Consultee Comments for Planning Application 21/00677/FUH

Application Number: 21/00677/FUH

Address: Maple Brook Cottage Lower Lane Chorley Lichfield Staffordshire WS13 8DG

Proposal: Erection of front boundary wall and entrance gates

WALL ELEVATION 1.100

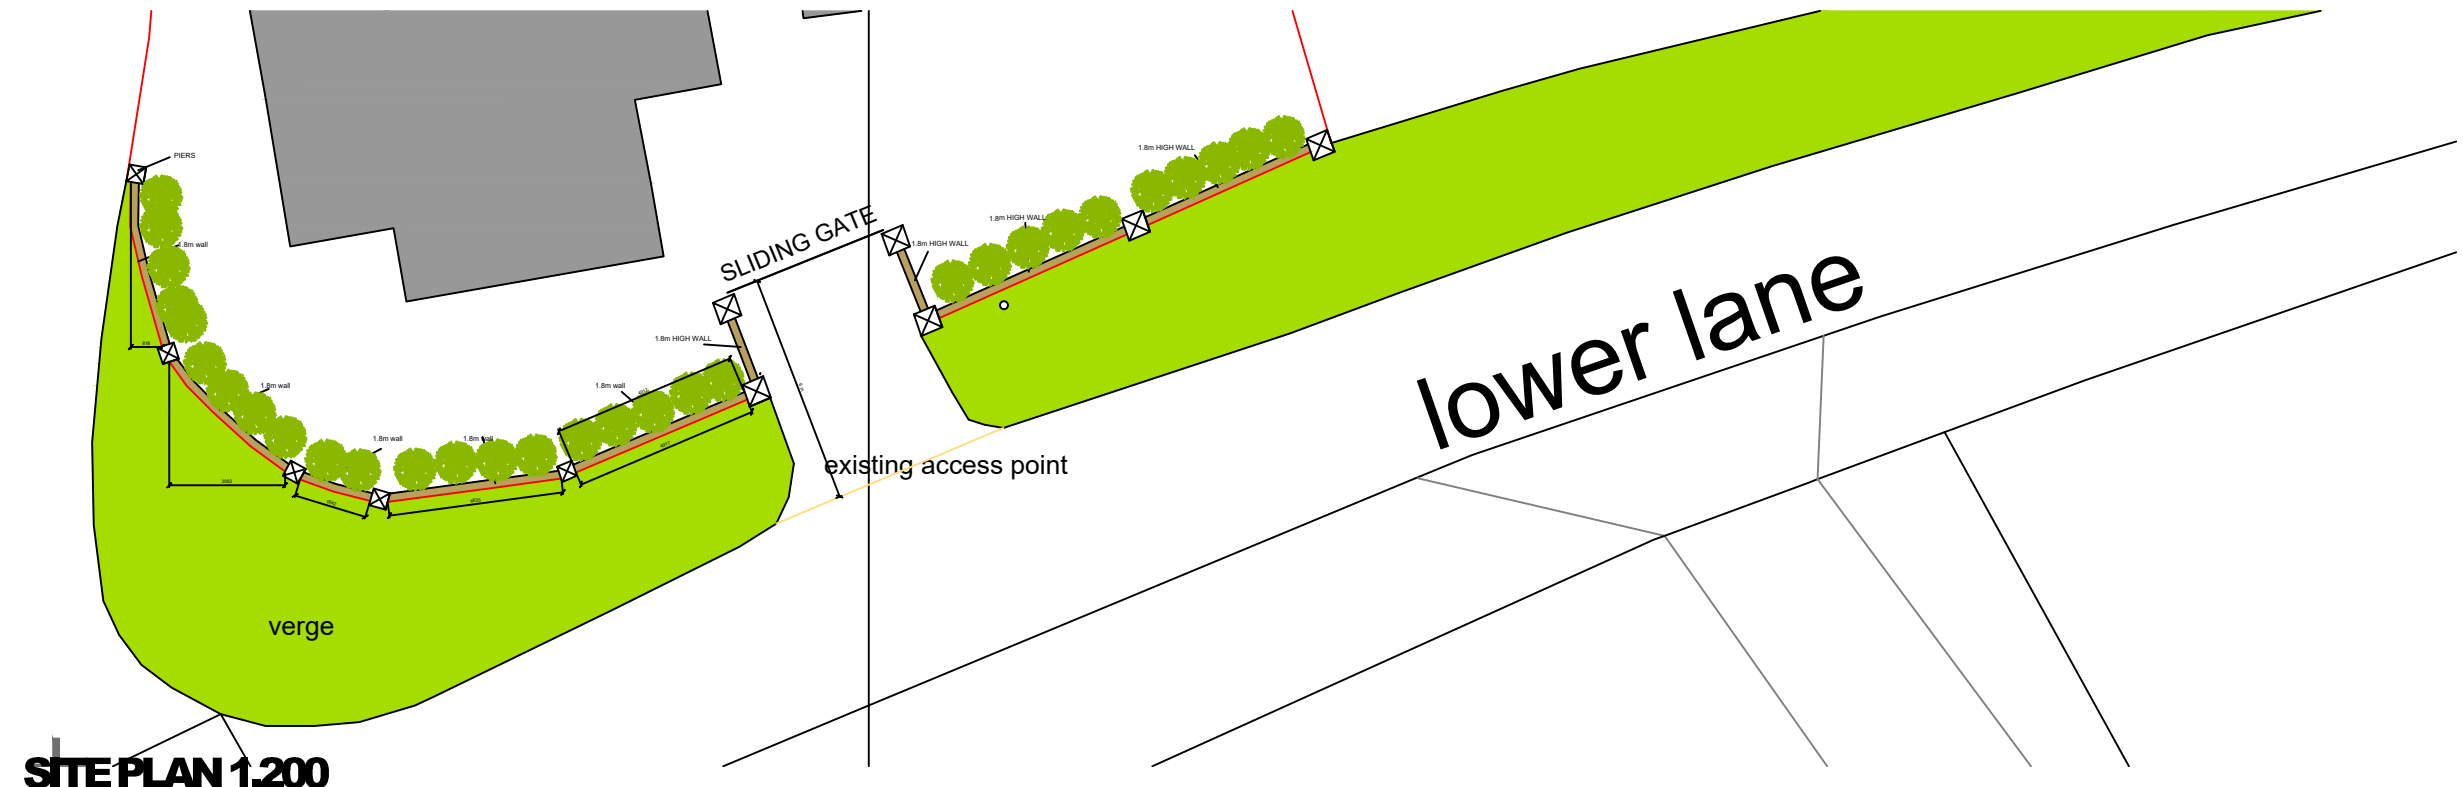
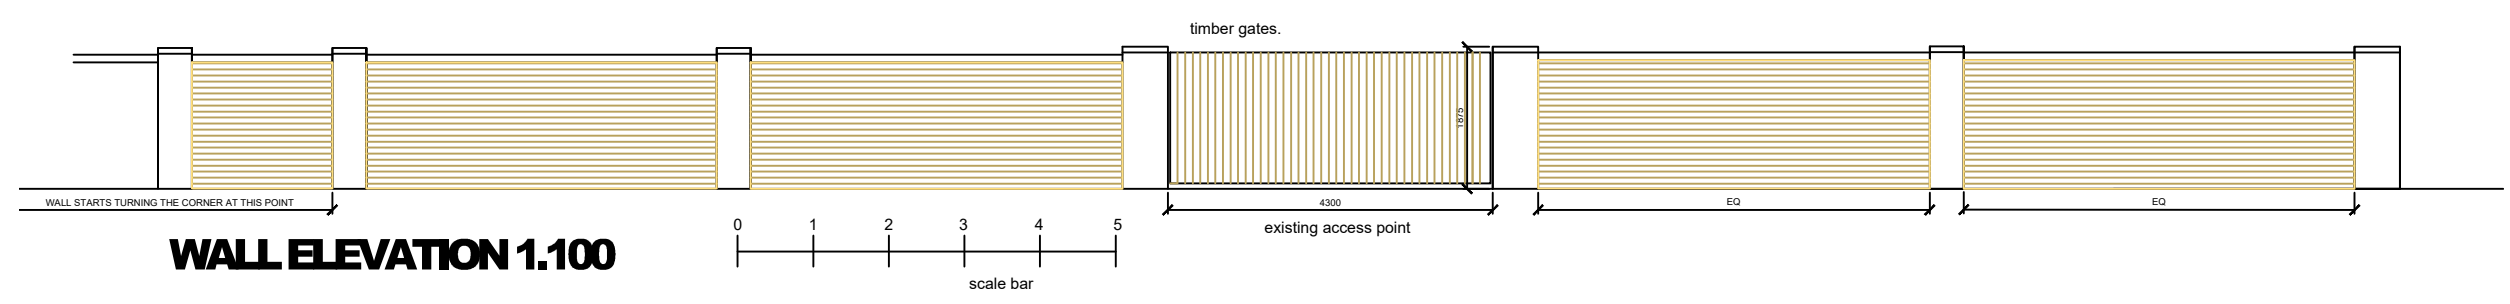
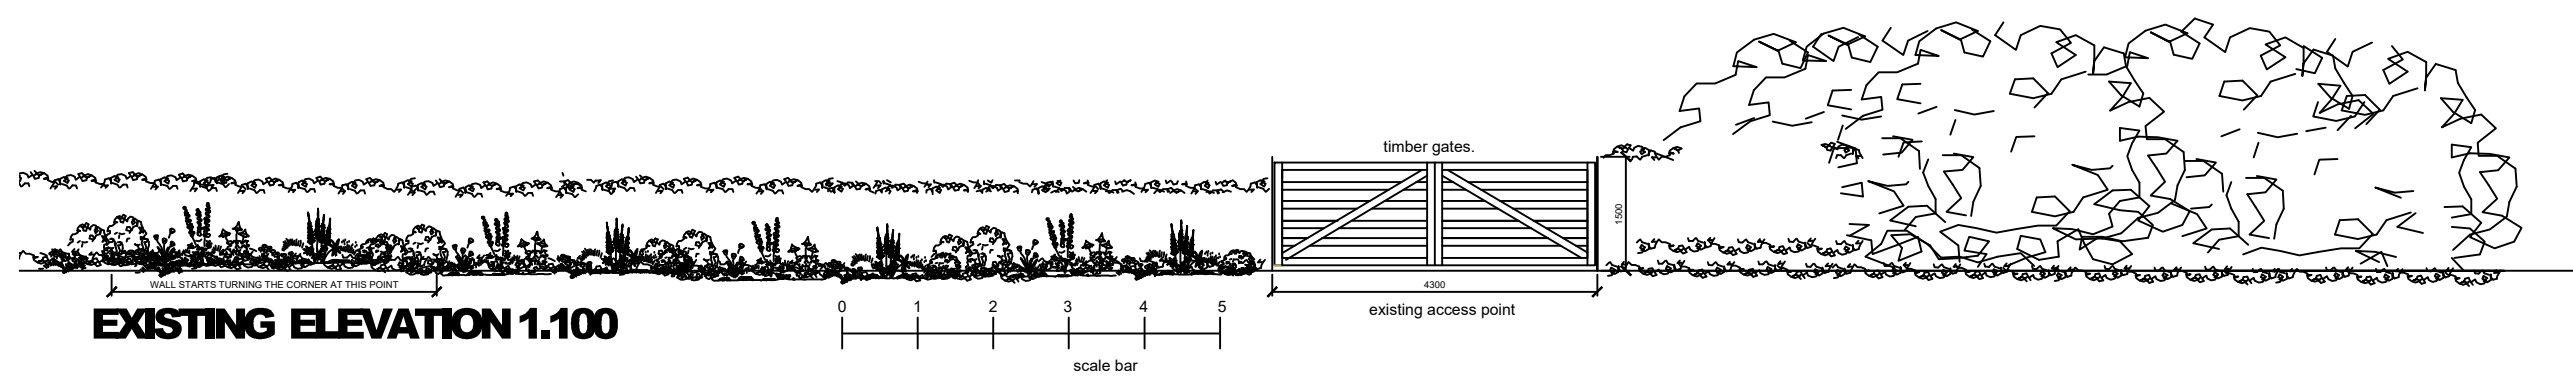
The site is not within any designated conservation area and currently there are no TPO's, and it does not appear that there are large trees affected although it is clear the hedge to the frontage will be lost.

The streetscene within this area is rural in nature, and whilst the hedges are domestic curtilage they do provide a natural screen along with high wildlife value. The proposed wall, whilst not detailed, would clearly have a very negative affect visually and we would ask the applicant to consider this and include some landscaping to soften this impact.
